Re: Location: Sumara The Warren Ferring BN12 5PQ per your letter 3rd May
Your Ref: FG/74/22/HH

Cura Design Drawing LO1A – Revised location plan boundary
Cura Design Drawing LO2A – Dimensions added to existing and proposed block plan

Drawing Number:
LO1A

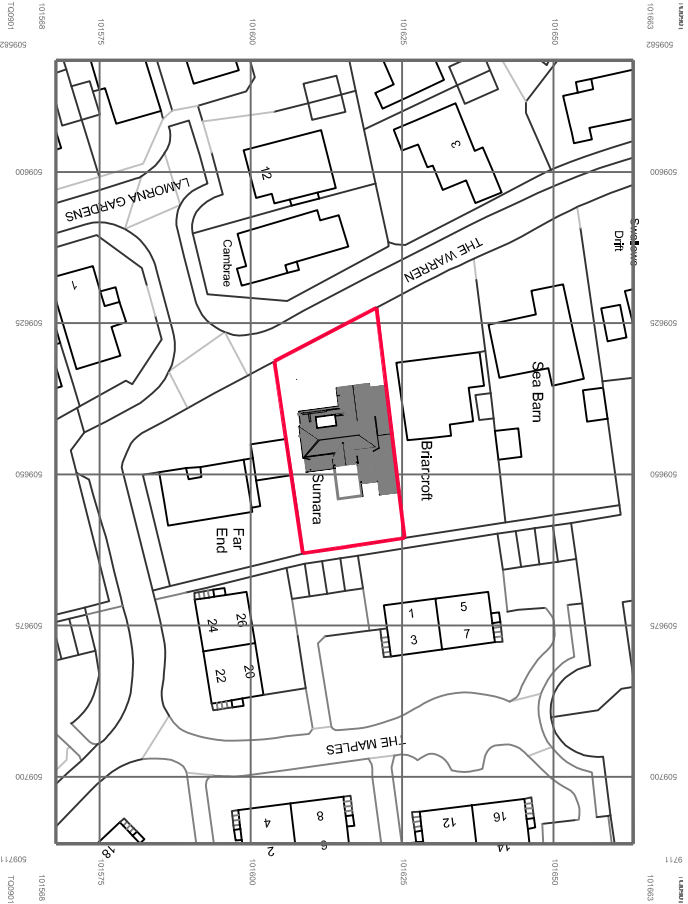
We have amended the site boundary on drawing LO1A and added dimensions illustrating changes to the building footprint on the existing and proposed block plan.
I look forward to your response. Please advise if you require any further information to validate this application.
